RELEVANT REPRESENTATION SUMMARY

Project: East Park Energy

Applicant: BSSL Cambsbed 1 Limited

Your Ref: EN010141

- KEY**
- Grade 1
 - Grade 2
 - Subgrade 3a
 - Subgrade 3b
 - Grade 4
 - Grade 5
 - Non-agricultural
 - Not surveyed

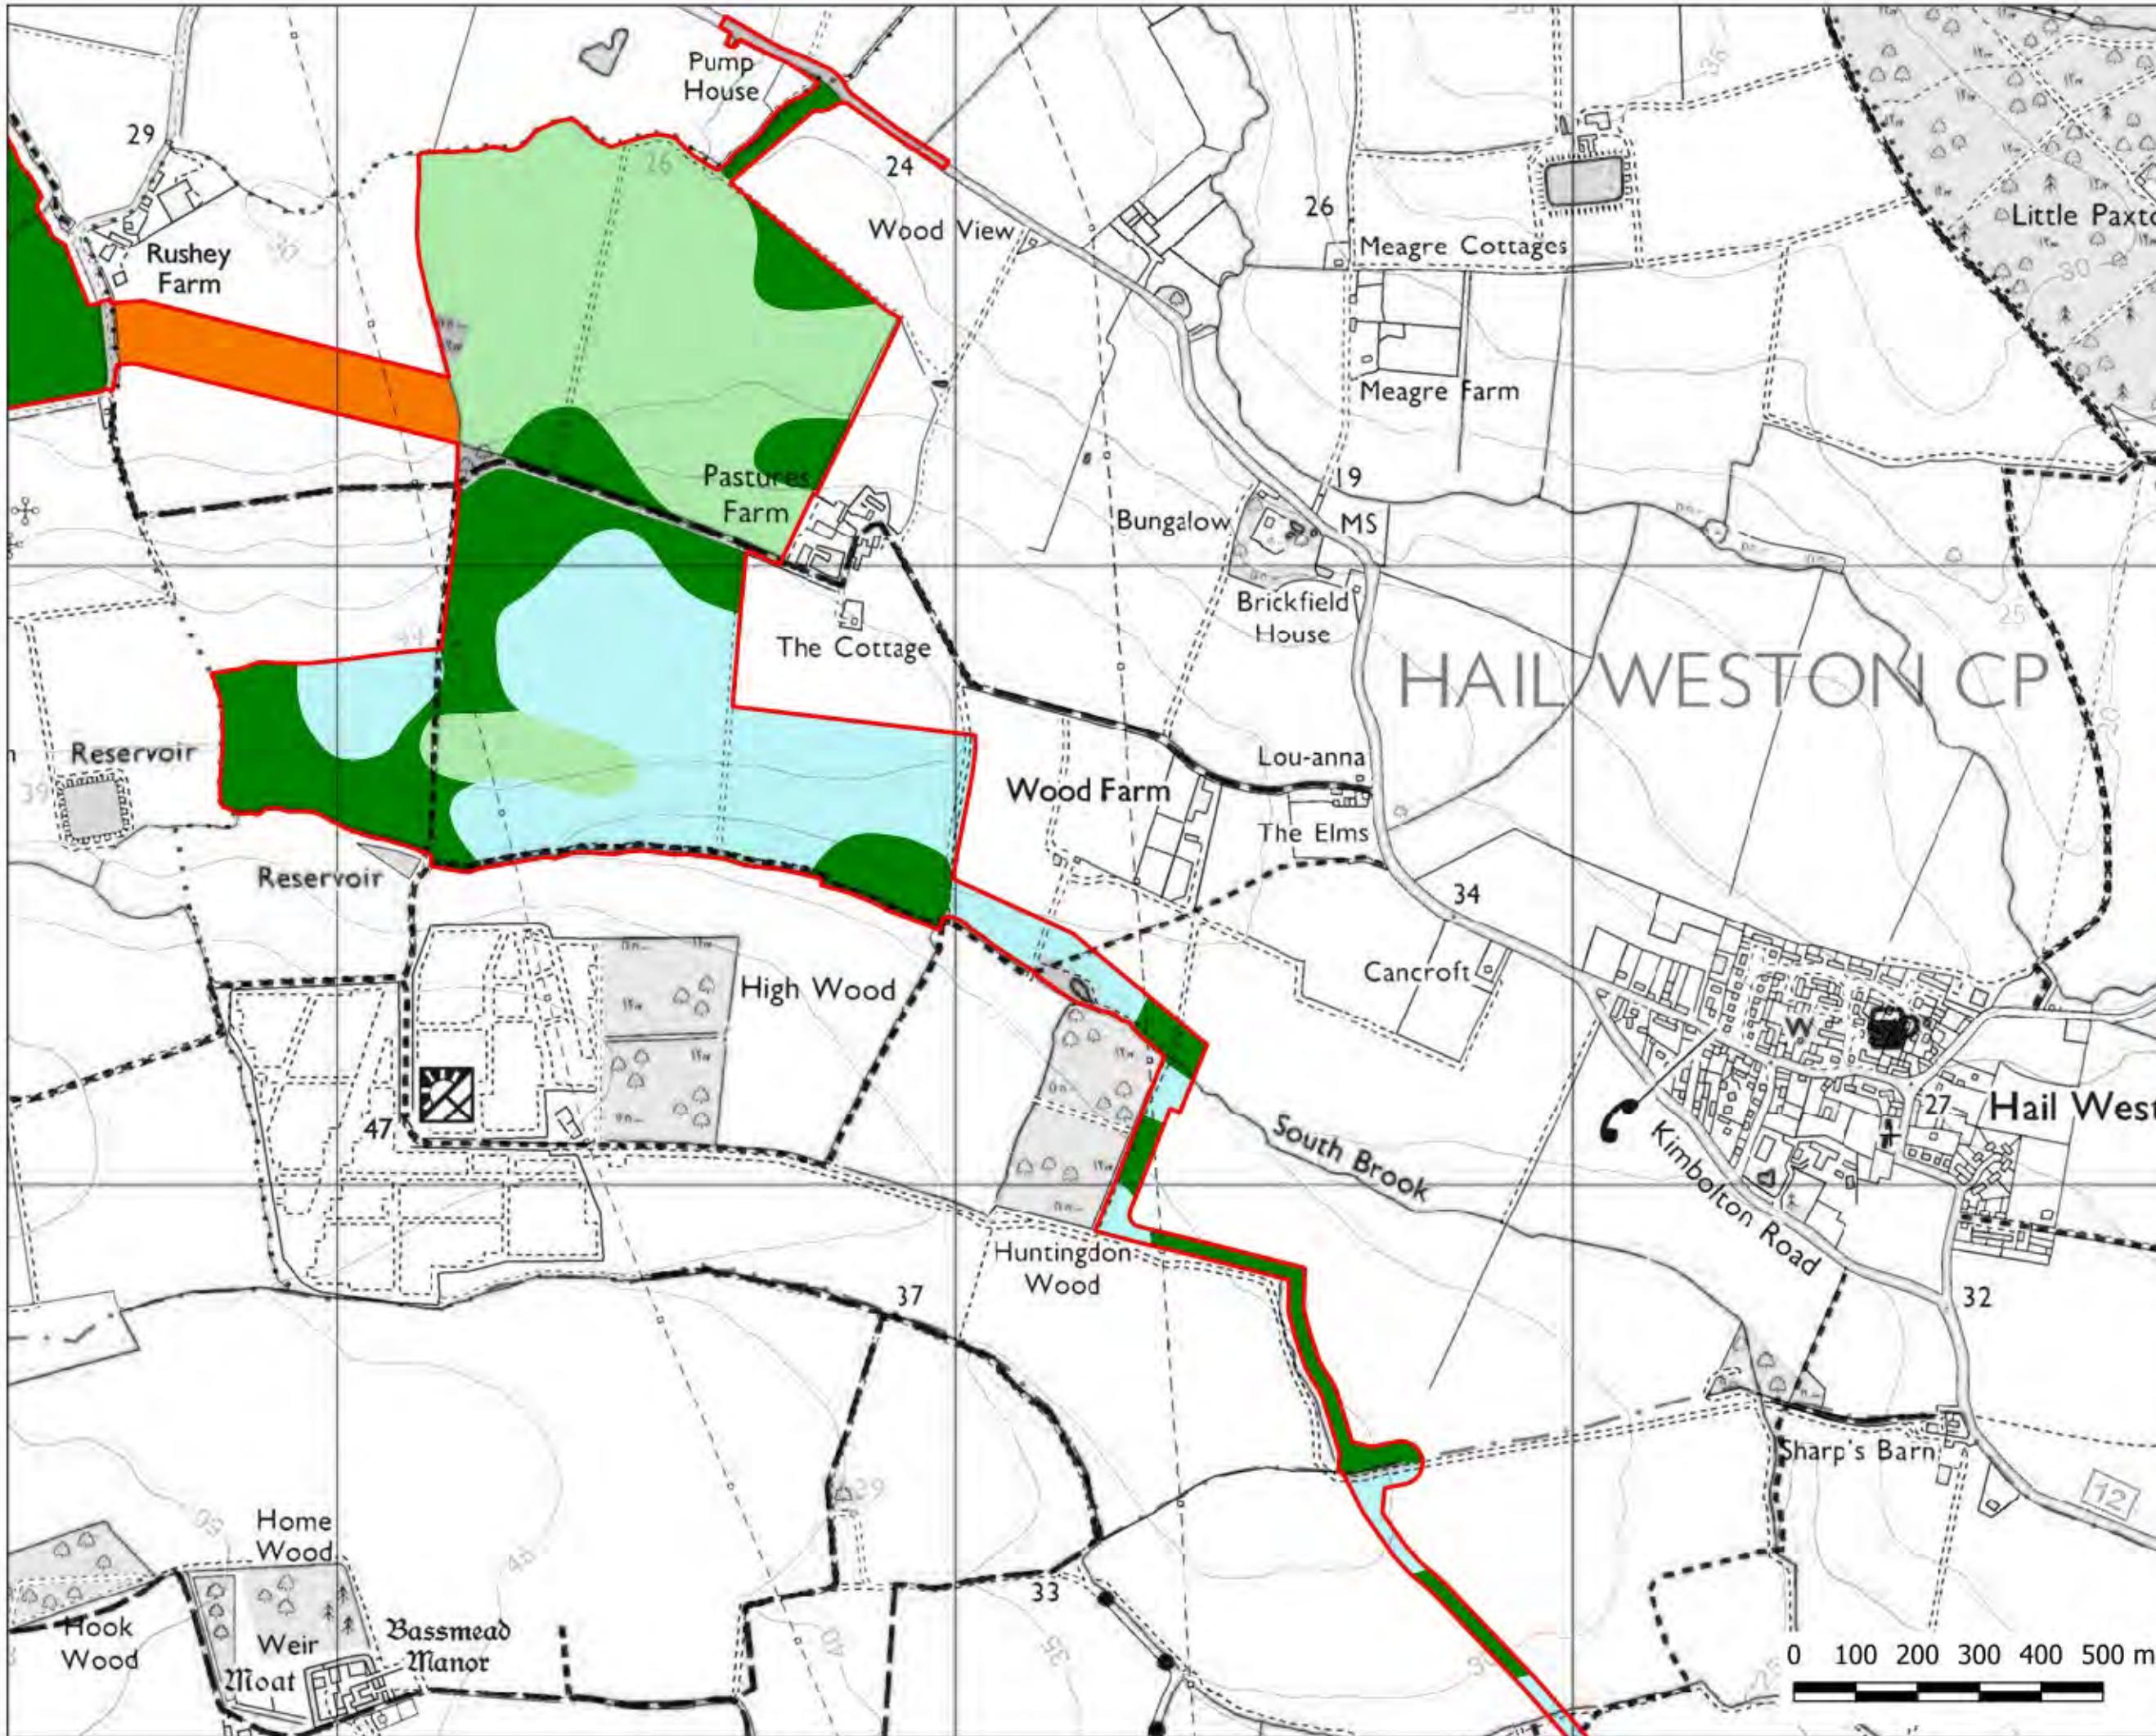
- missing Agricultural Land Classification (ALC) data for 5.4% of the site;
- underrepresentation of permanent land-use change resulting from woodland and hedgerow creation;
- potential understatement of effects on Grade 2 and 3a land;
- likely overstatement of beneficial soil effects during operation.

10.2 Further detail is required to justify conclusions on residual effects.
